# 7280 NEVADA LANE

### GRADING AND EROSION CONTROL PLANS

PCD FILING NO. : PPR-2411

COVER SHEET

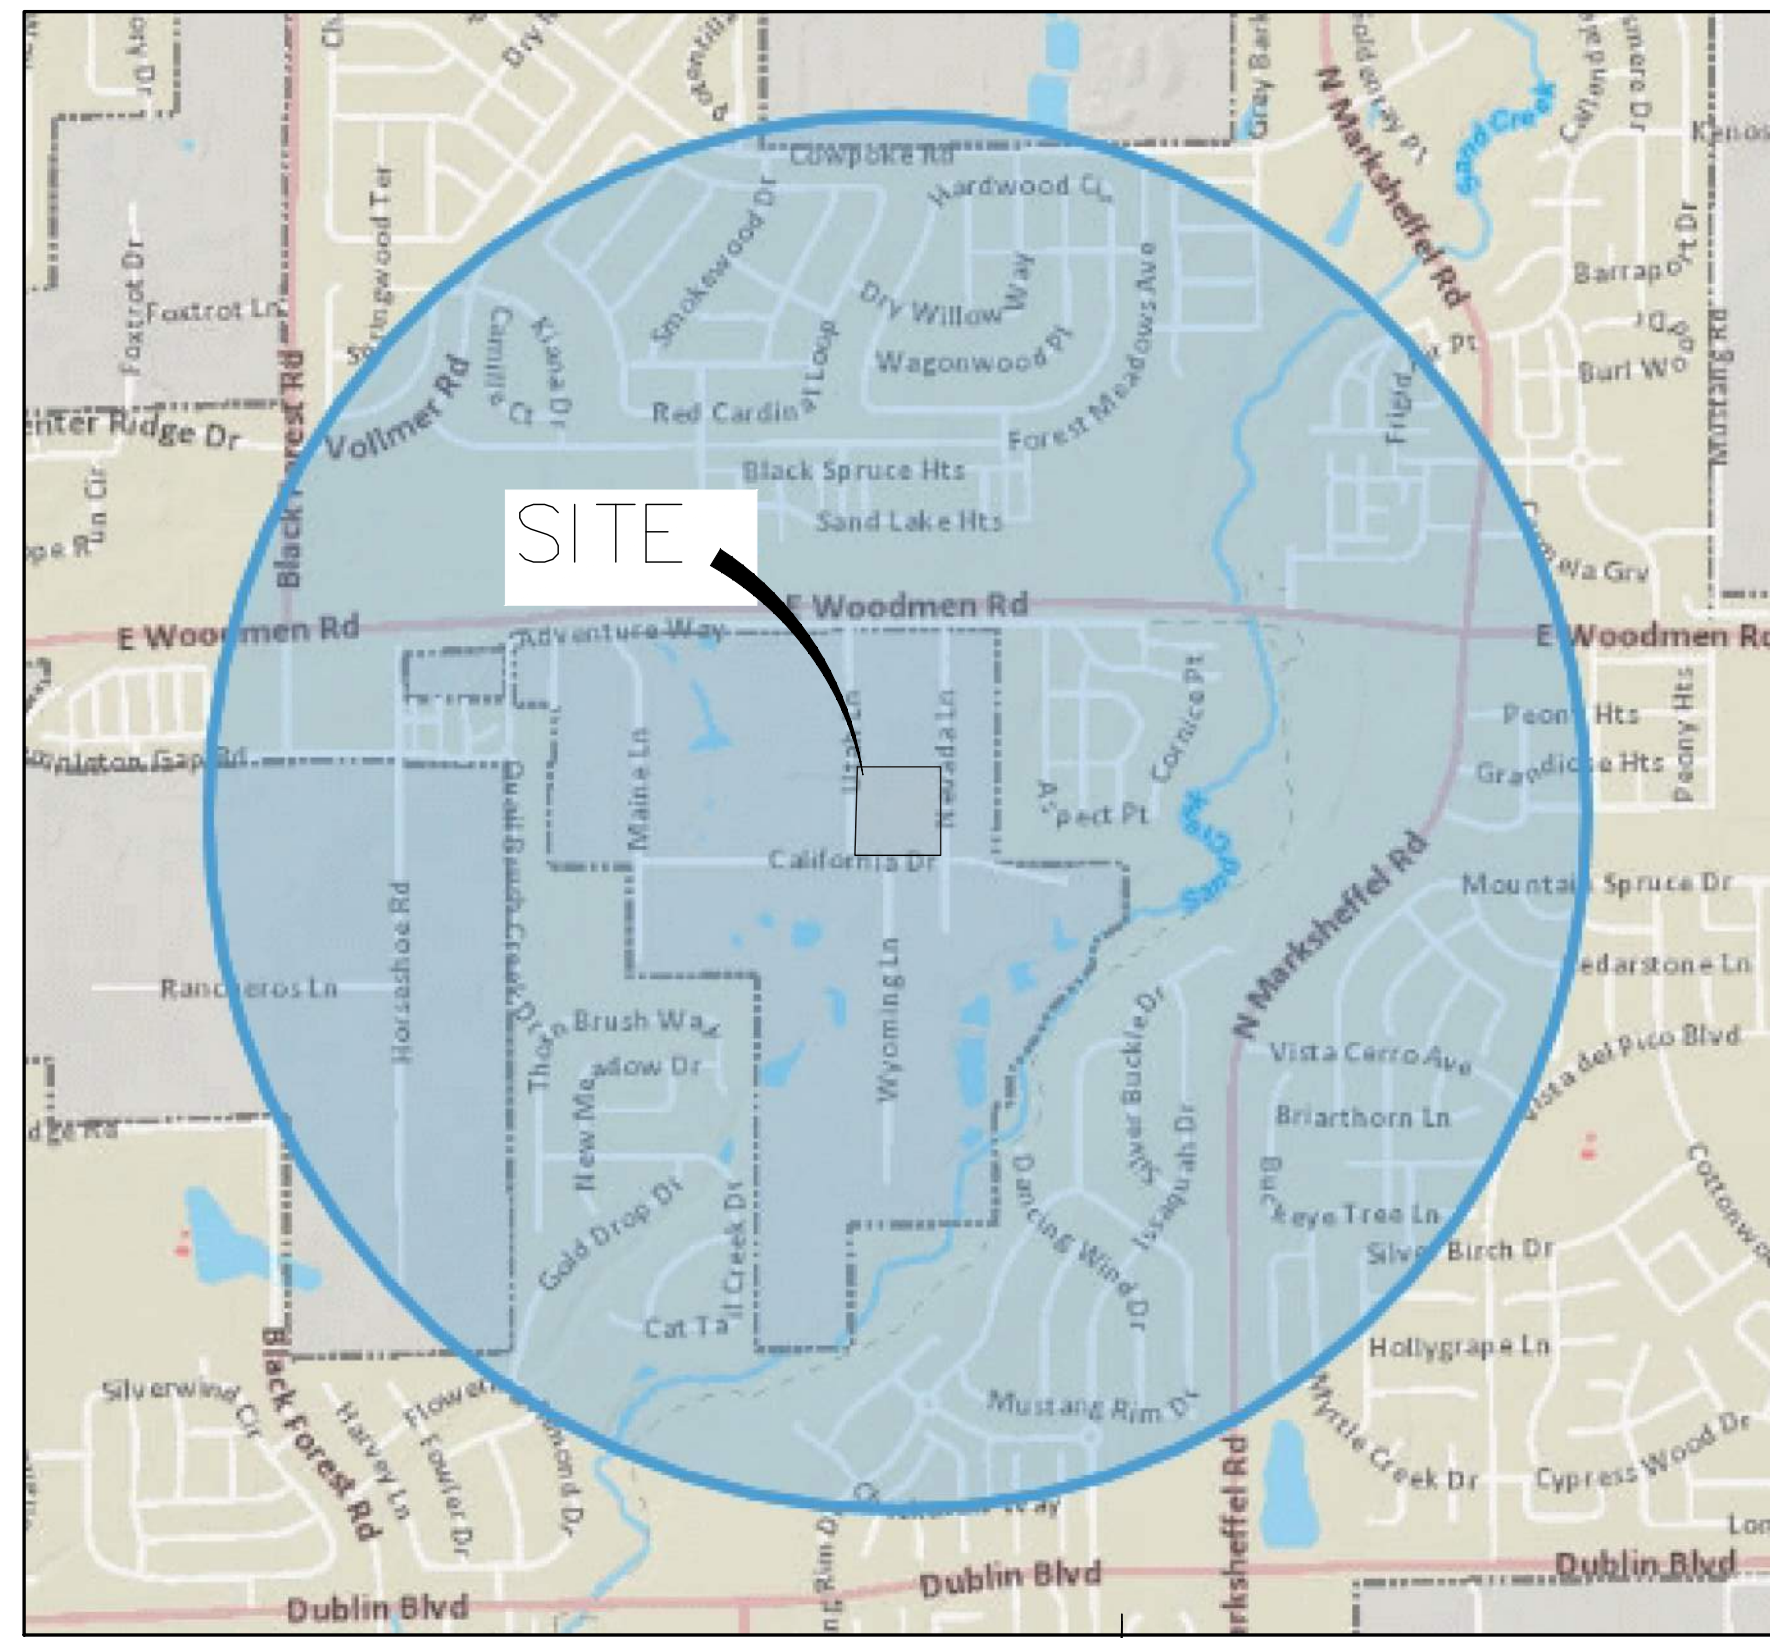
Please update to match # of sheets

**LEVEL SPREADER SECTION B-B**  
SCALE: N.T.S.

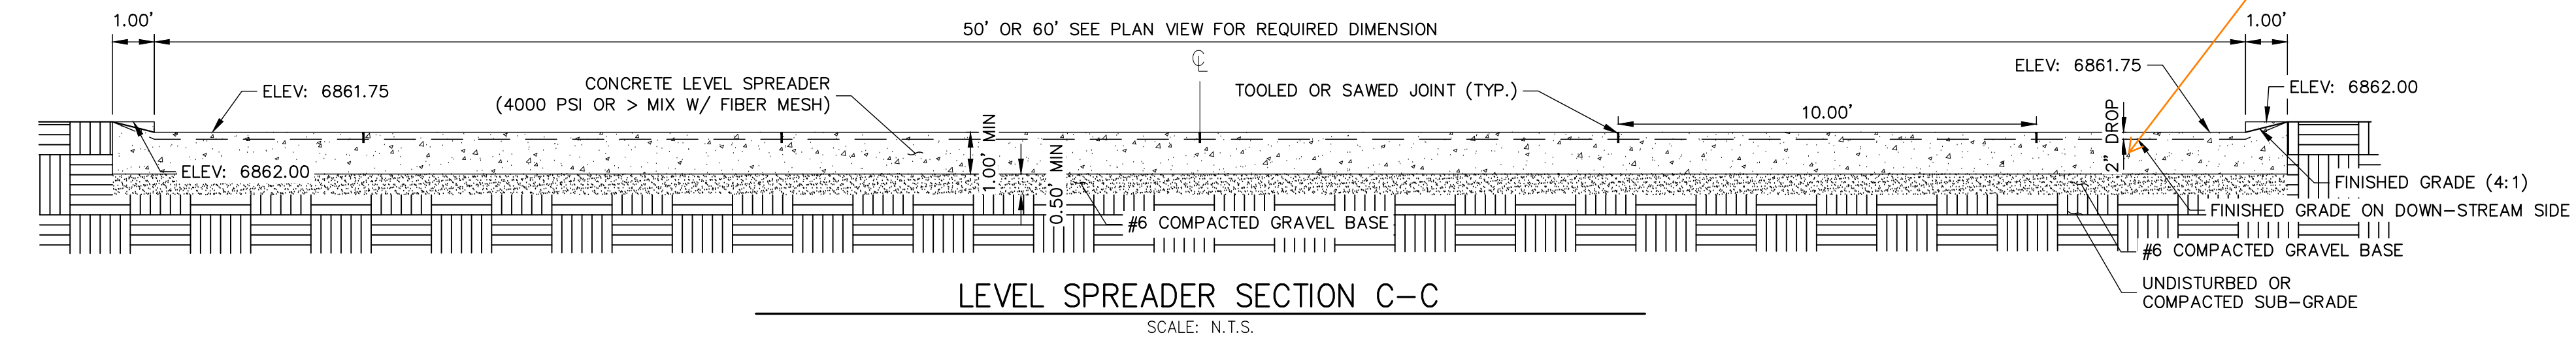
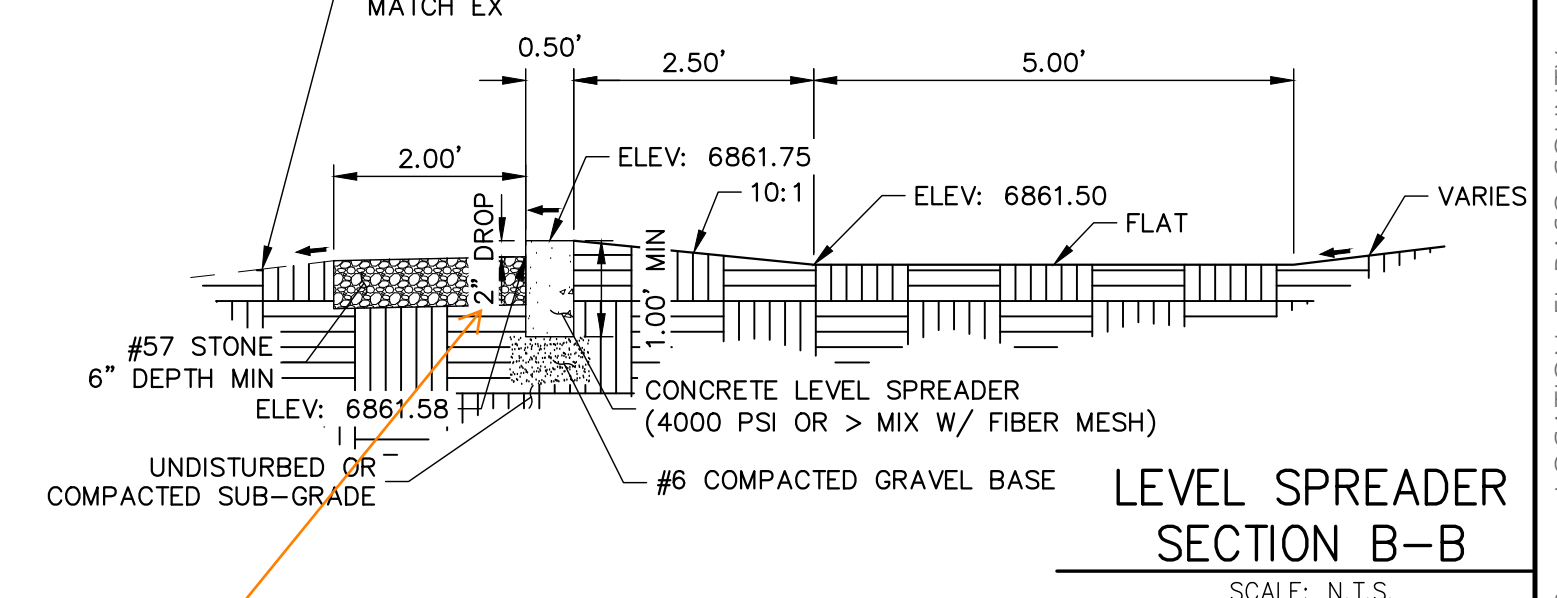
Note that MHFD's latest RR guidance (March 2024) recommends a min 3" vertical drop. But I understand if this site is too flat to accommodate this.
